Felks Stile Road / Blackmoorfoot
Road, Huddersfield

Stage 2 Road Safety Audit
Response Report

CLIENT: Miller Homes & Vistry Homes Limited
PROJECT TITLE: Felks Stile Road / Blackmoorfoot Road,
Huddersfield
REPORT TITLE: Stage 2 Road Safety Audit Response Report
PROJECT REFERENCE: 169635
DOCUMENT NUMBER: 169635-SAN-BMF-RP-02
ISSUE NUMBER: 001
DATE: April 2026

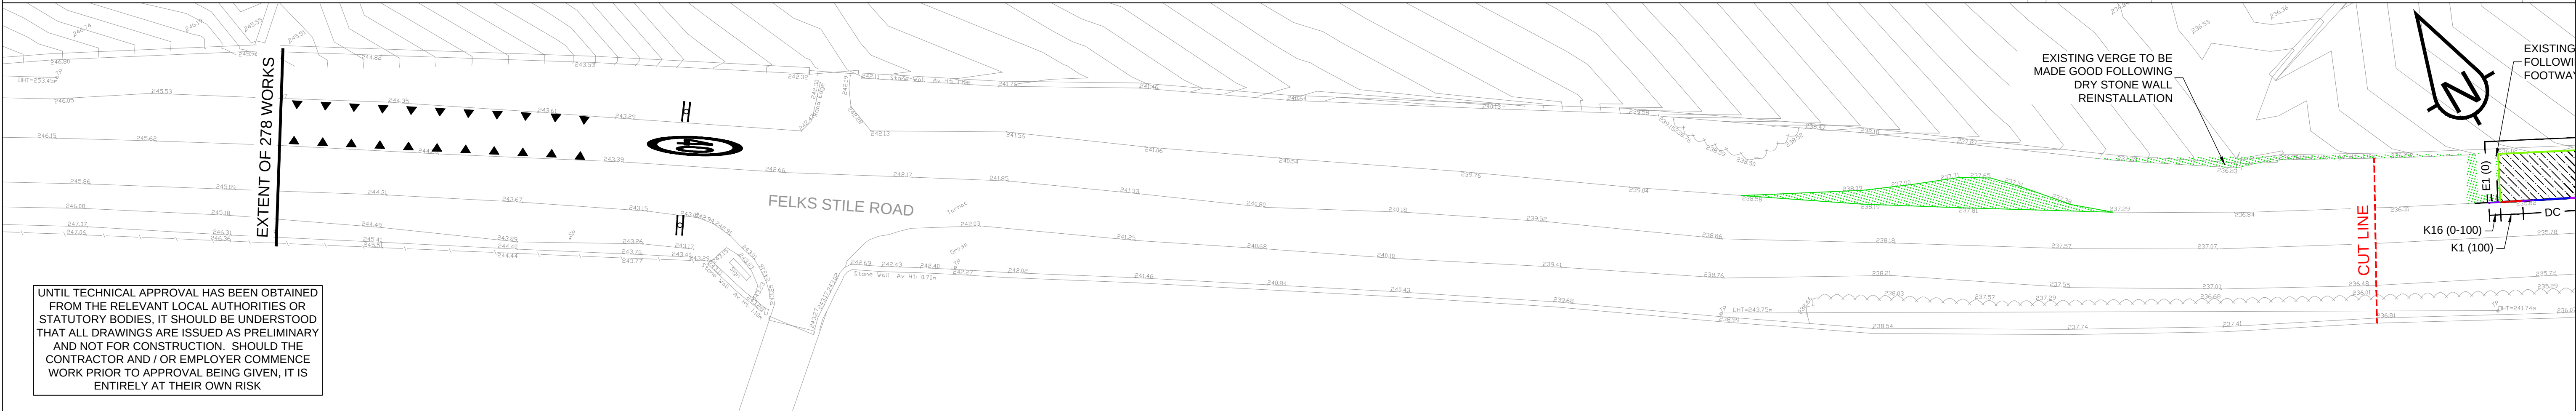
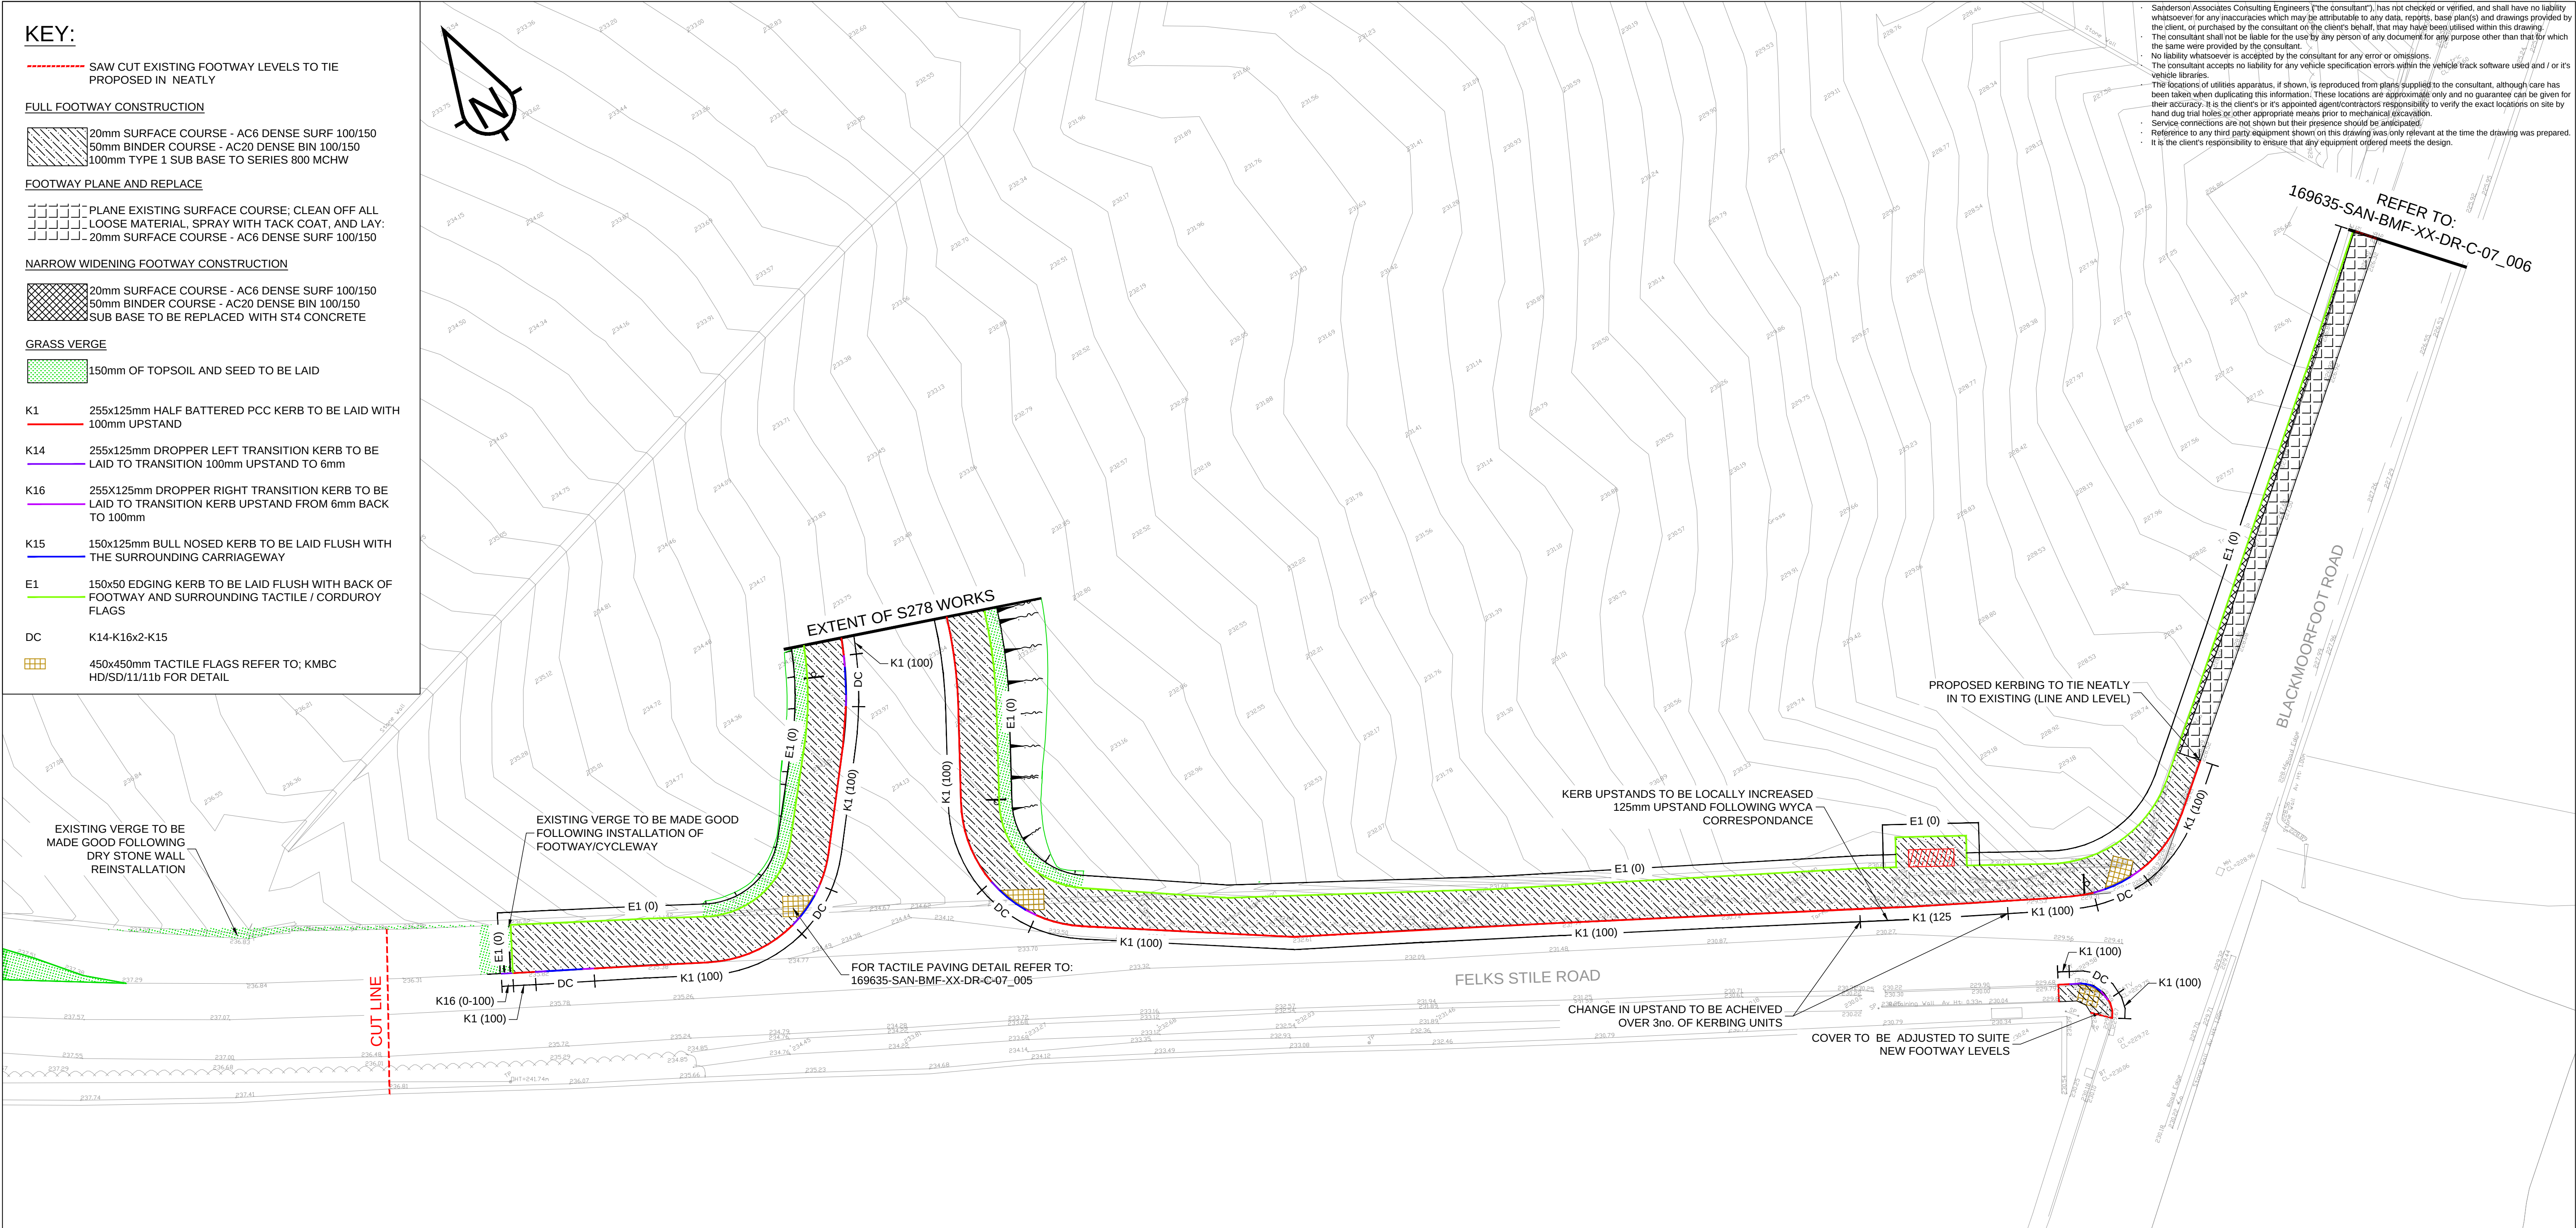
A new footway with kerbs is to be introduced along the full frontage of the Site. Currently, a drainage ditch is provided along the southern boundary of Felks Stile Road, however it appears some surface water may drain into the existing grass verge along its northern flank. The introduction of kerbing along the full length of frontage will prevent this and may overwhelm the existing gully at the Blackmoorfoot Road/Felks Stile Road junction.

The absence of formal drainage may result in standing water, leading to potential loss of control incidents, particularly during poor or freezing weather conditions.

It is recommended that suitable drainage is provided along the frontage of the Site as part of the detailed design of the scheme, or it is demonstrated that the existing drainage system is suitable to accommodate the increased run off.

Recommendation accepted: The detailed Section 278 design will incorporate appropriate drainage, such as gullies into the design along the northern kerb line at appropriate spacing and outfall via a pipe to the existing ditch on the southern side of Felks Stile Road.
